The Member Secretary,  
Madras Metropolitan  
Development Authority,  
Thalamuthu-Natarajan Building,  
No.8, Gandhi Irwin Road,  
Egmore, Madras-600 008.

D.Dis.A/1/19414/89, dated: 20-2-'90

Sub: MMDA - Planning Permission - Construction of  
residential building at No.795 at S.No.311/2,  
Trunk Road of Poonamallee village - Approval  
Regarding

FIRST FLOOR PLAN

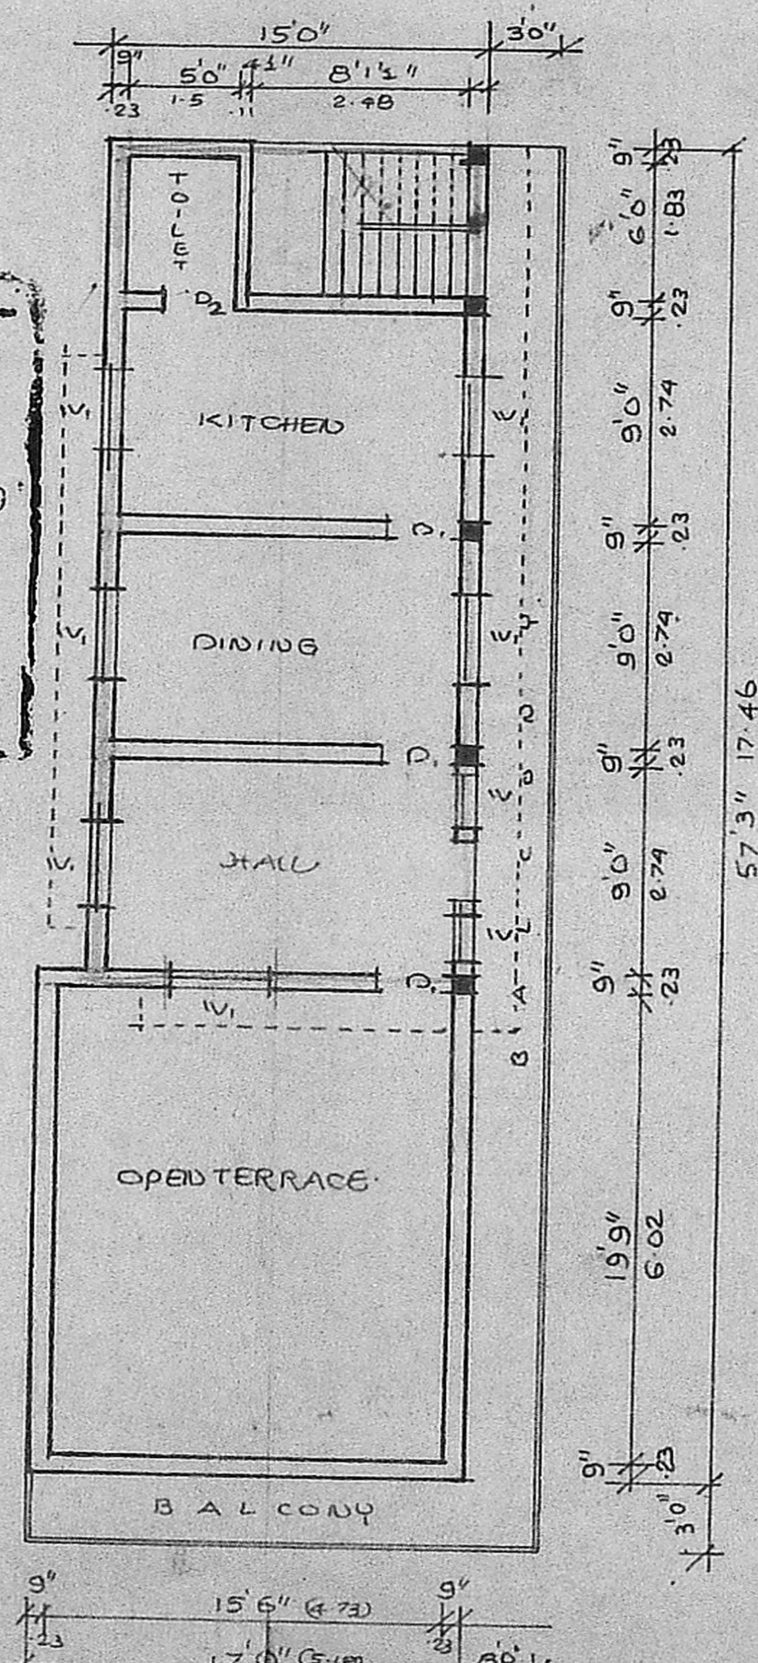
The revised plans submitted by the applicant  
directly to this office was examined and found that the planning  
permission for the same is issuable subject to condition that **building**

**/\* should not be constructed**

**in front open space in first floor, and**
